CITY OF ALBUQUERQUE

Re: Certification Submittal for Final Building Certificate of Occupancy for
TSI CAR & TRUCK ACCESSORIES REMODEL, [H-17/D66]
4016 Menaul Blvd. NE
Architect's Stamp Dated 04/03/2006

**Re: TSI Cars & Truck Accessories Remodel, 4016 Menaul-Traffic Circulation
Layout Architect's Stamp dated 12-06-05 (H17-D66)**

**Re: TSI Cars & Truck Accessories Remodel, 4016 Menaul-Traffic Circulation
Layout Architect's Stamp dated 12-06-05 (H17-D66)**

Proposed Site Plan

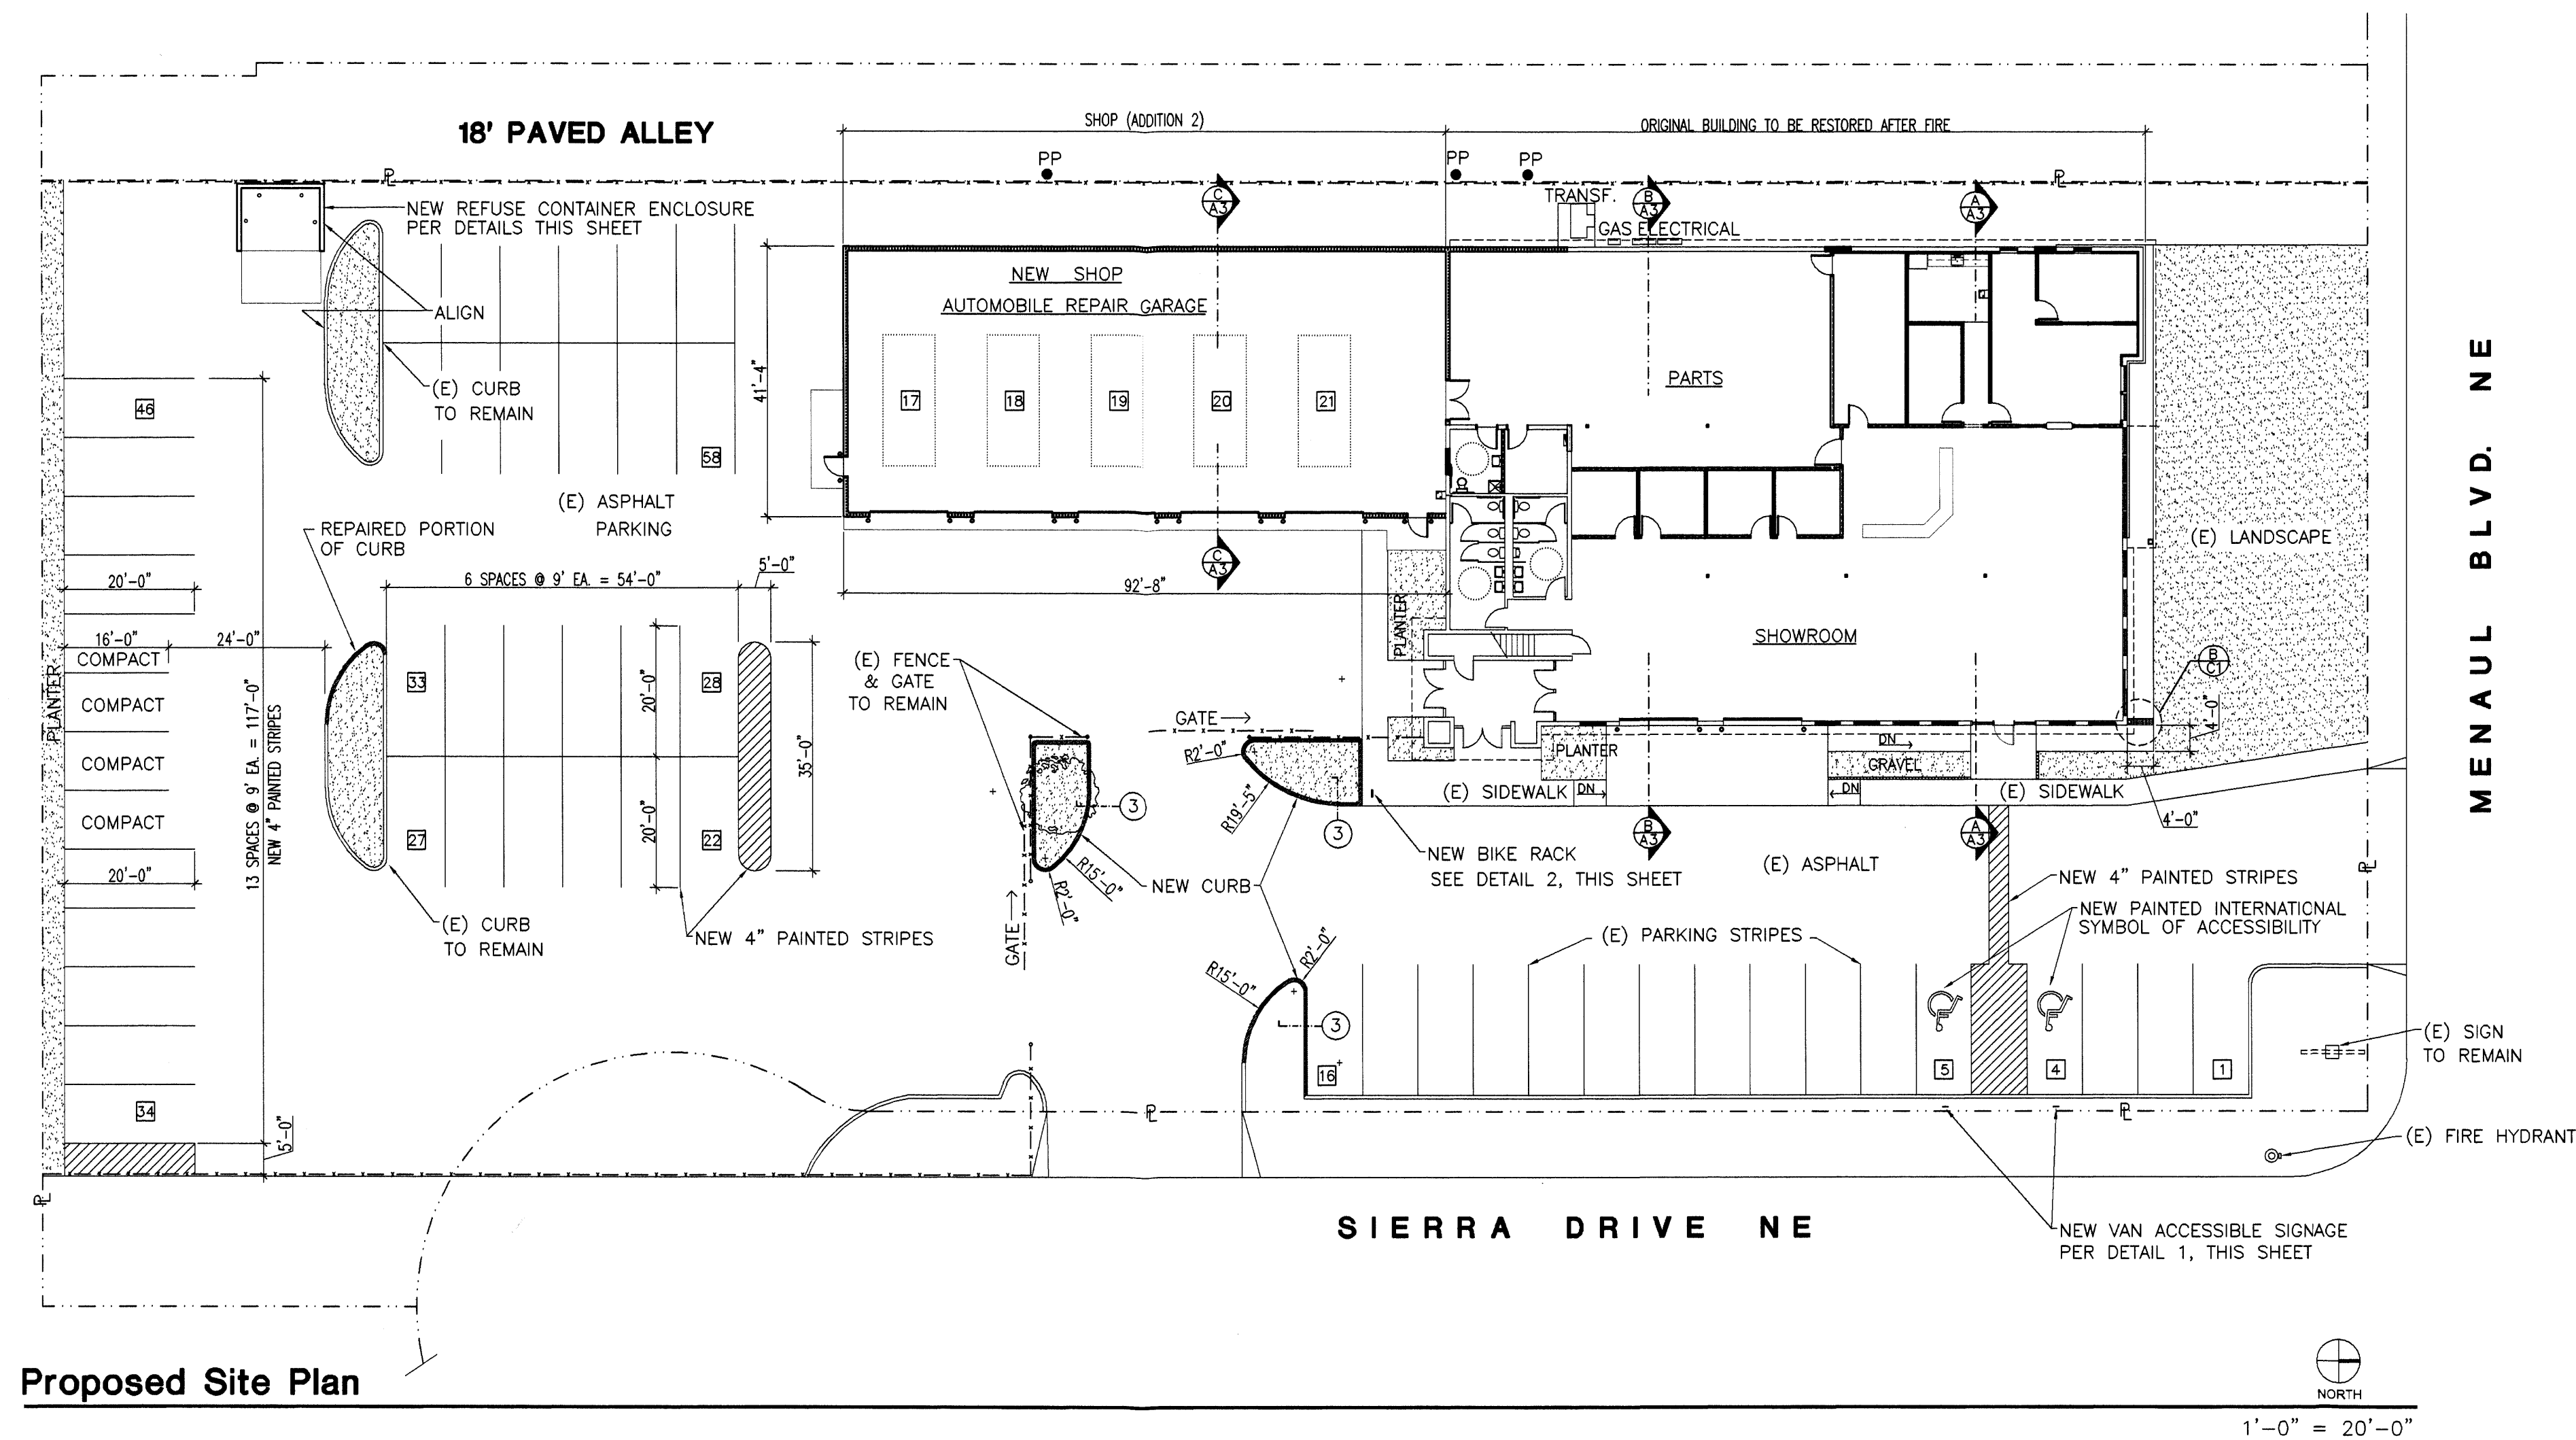
- P.O. Box 1293
Albuquerque
New Mexico 87103
- ✓ • Provide parking calculations.
 - ✓ • Include a vicinity map.
 - ✓ • Label all parking stalls.
 - ✓ • The compact parking stalls need to be labeled "compact" on the pavement.
 - ✓ • Provide solid waste approval. *attached*
 - ✓ • Call out and provide dimensions of the sidewalk along Sierra Drive and Menaul Blvd.

- Provide parking calculations.
- Include a vicinity map.
- Label all parking stalls.
- The compact parking stalls need to be labeled "compact" on the pavement.
- Provide solid waste approval.
- Call out and provide dimensions of the sidewalk along Sierra Drive and Menaul Blvd.
